**Re: PA22-024- Marysville 44<sup>th</sup> PRD – Technical Review 2**  
7315 / 7417 44<sup>th</sup> St NE – APN(s) 30053500303700 / 30053500303600

After preliminary review of the above referenced proposal, the Planning Division has the following comment(s):

PRELIMINARY PLAT

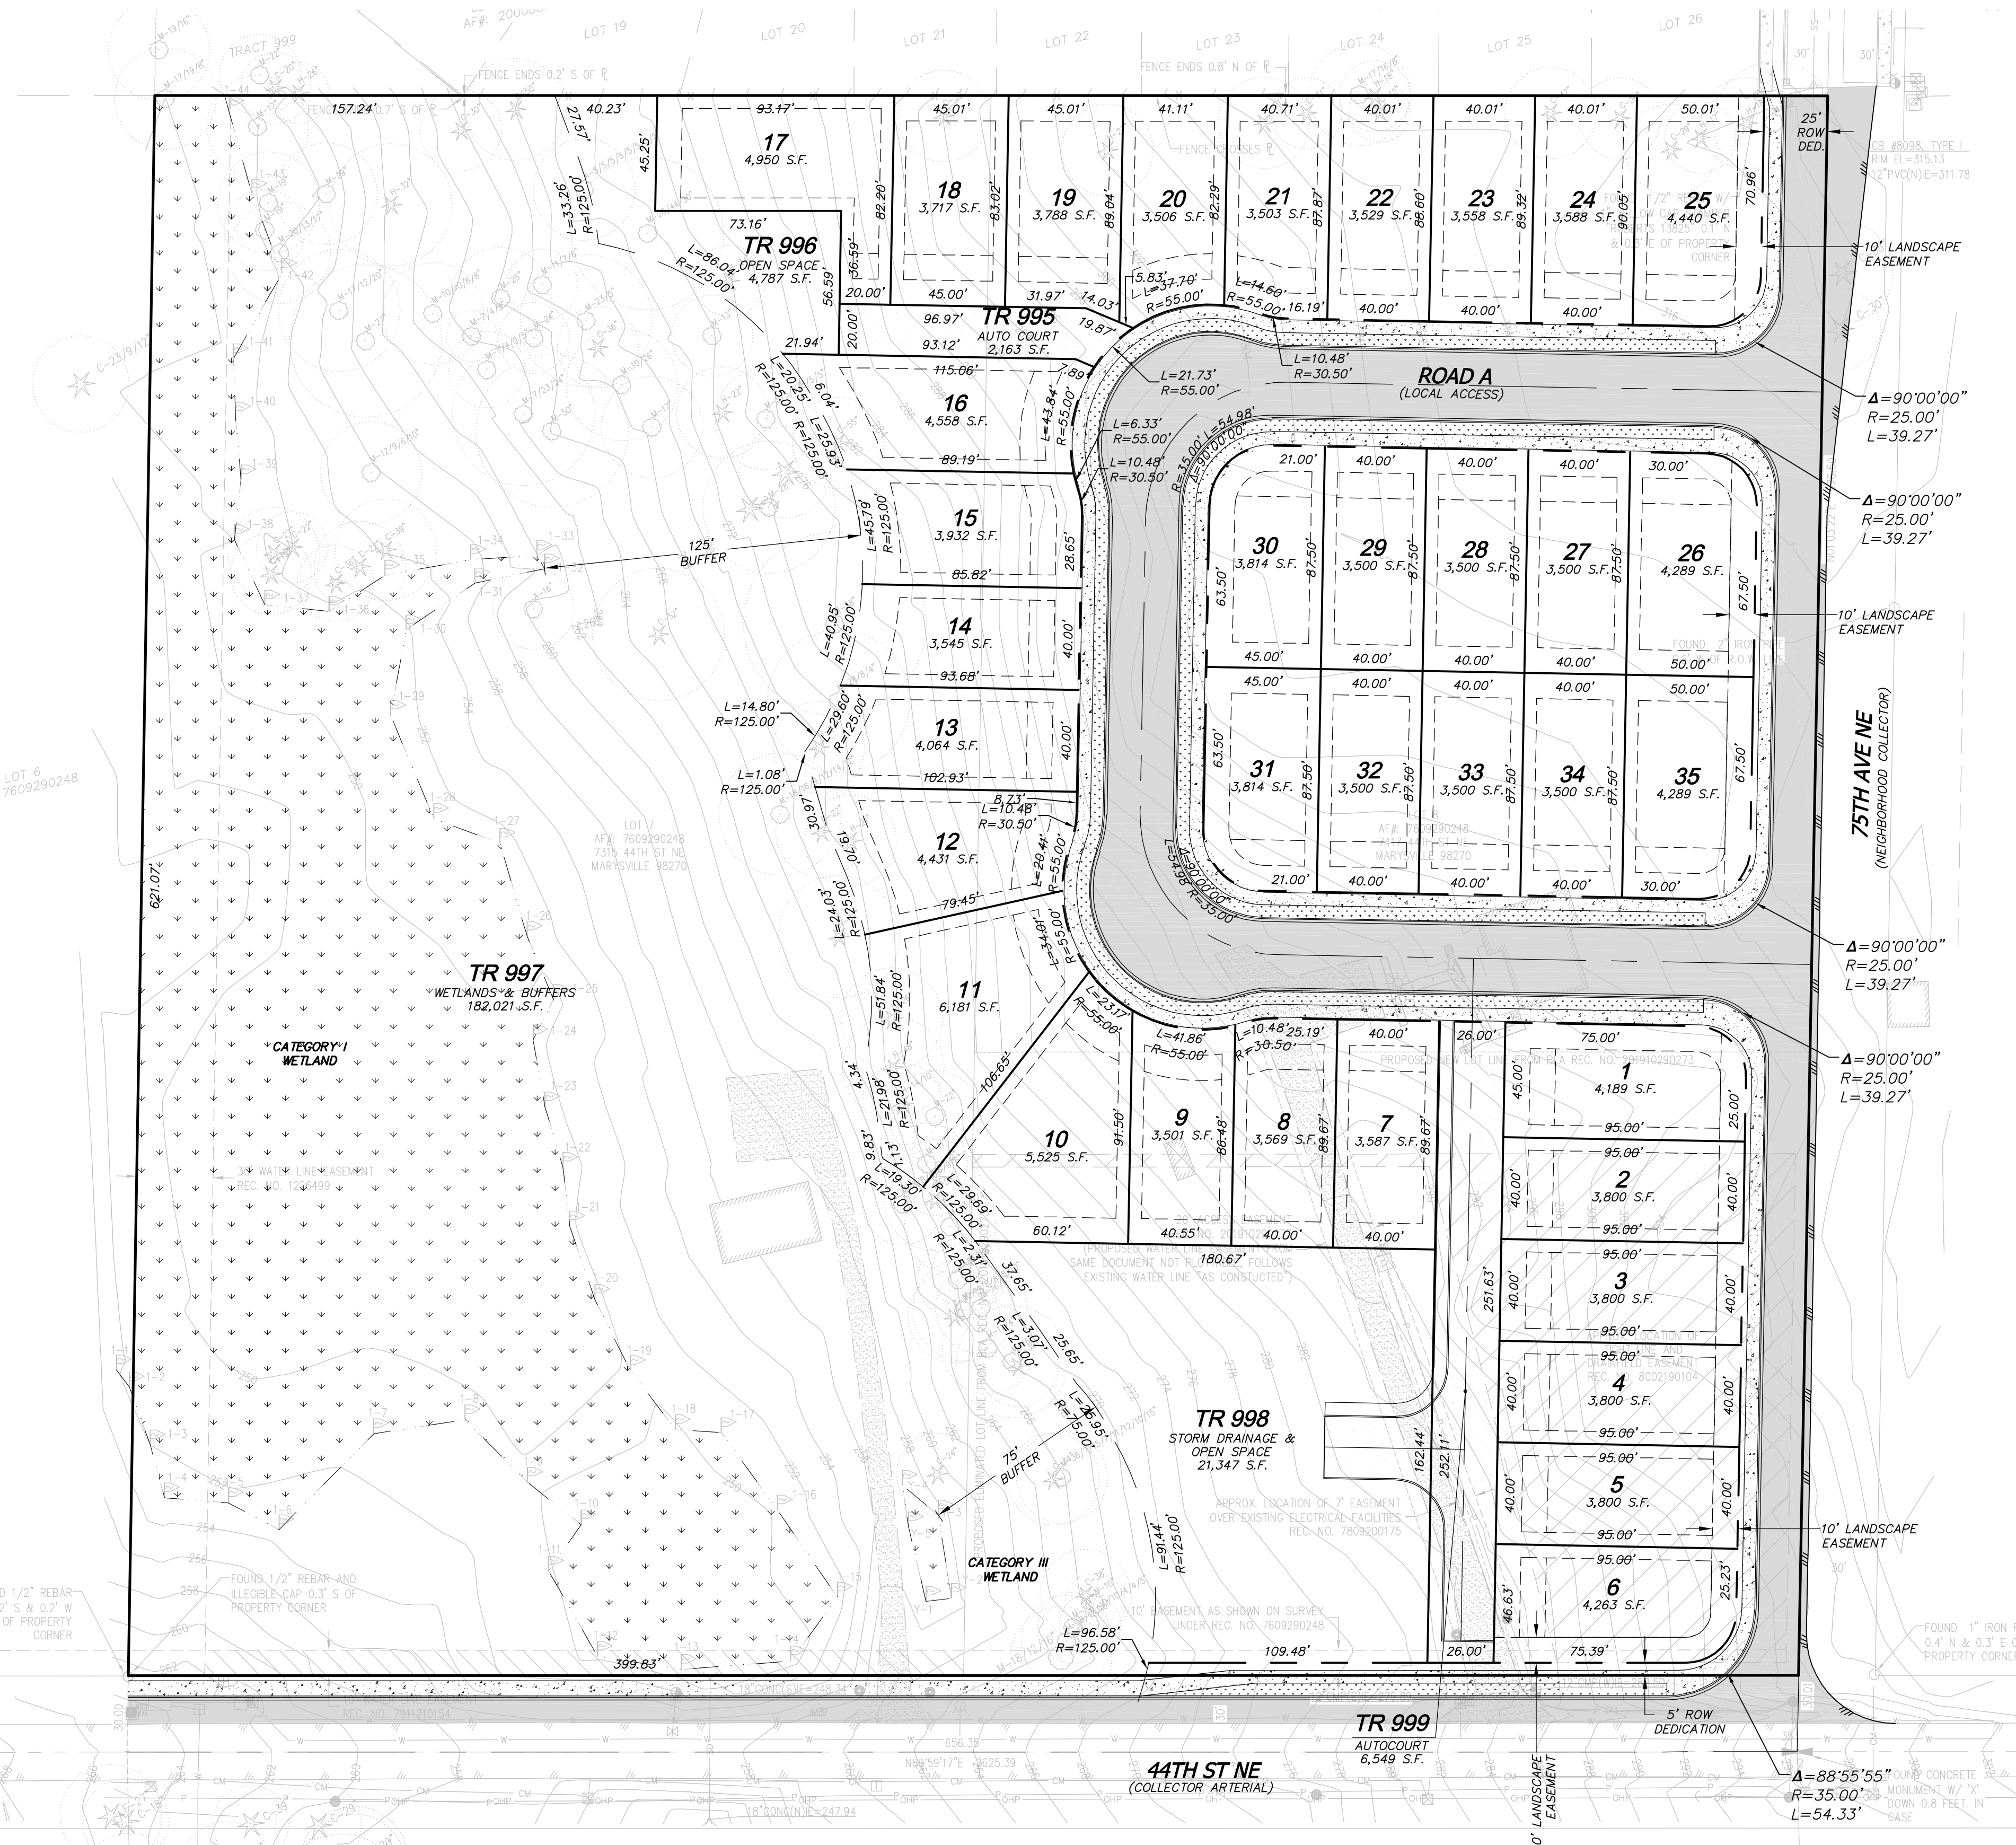
1. Where lots front on a public street, the house shall have doors and windows which face the street. Houses should have a distinct entry feature such as a porch or weather-covered entryway with an entry feature that is at least 60 ft. with no dimension less than 6 ft.

Lots 1 – 4 must be oriented towards 75<sup>th</sup> Ave NE with the vehicular access off of the proposed autocourt. Further, the proposed 10 ft. landscape easement shall be removed in order to allow pedestrian access from the front of the home to 75<sup>th</sup> Ave NE.

2. Demonstrate compliance with the following standards of MMC 22G.080.100(1): Fencing and/or landscaping shall separate, while maintaining visual observability of, recreation areas from public streets, parking areas, and driveways. Therefore, Tract 998 must be fenced as it fronts along 44<sup>th</sup> St. NE.

4. Please provide for pedestrian connection from Tract 998 to the sidewalk along 44<sup>th</sup> St. NE and 75<sup>th</sup> Ave NE.

LANDSCAPE PLAN

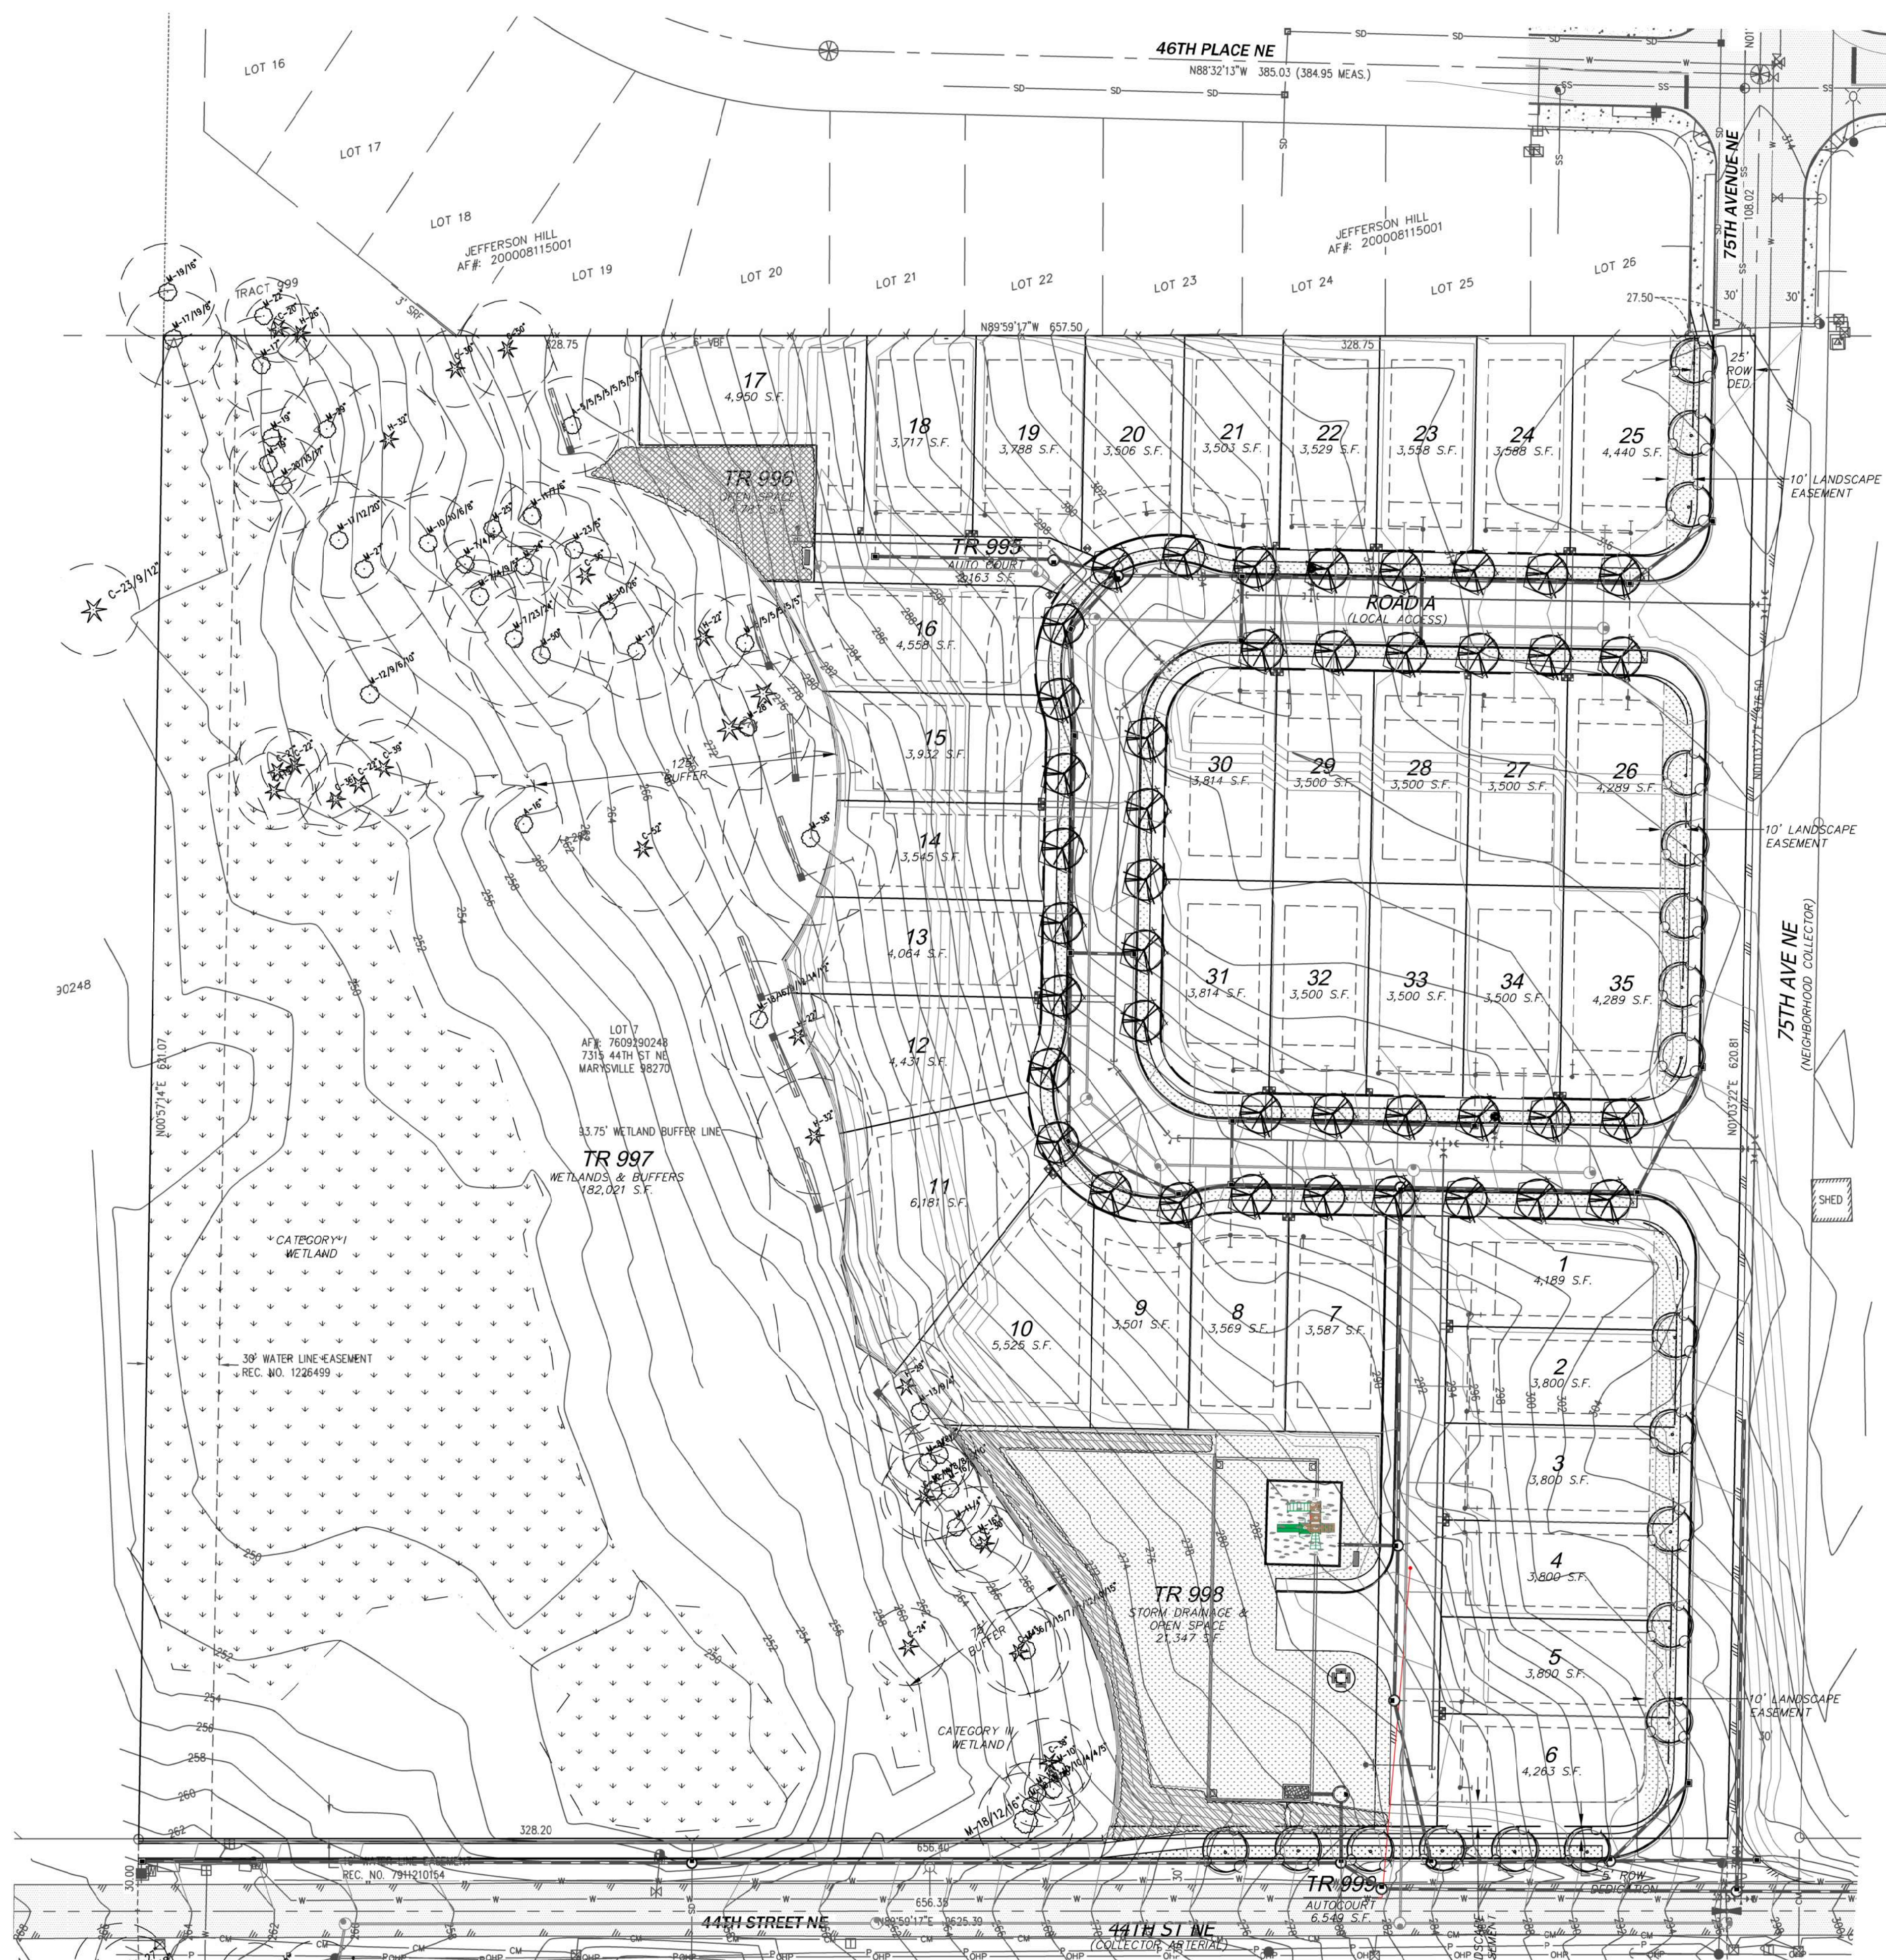
5. A final landscape plan shall be required to be approved prior to civil construction plan approval, and designed to comply with the applicable provisions outlines in MMC 22C.120, Landscaping and Screening. Specifically, please revise the Landscaping Plan to include:
  - 5.1. Incorporate the mitigation planting plan prepared by Raedeke Associates, Inc. to allow for a cohesive planting plan for the proposed development.
  - 5.2. Rather than dedicating (2) basketball courts in the active open space tract, a multipurpose sport court, tennis court, or similar should be included.
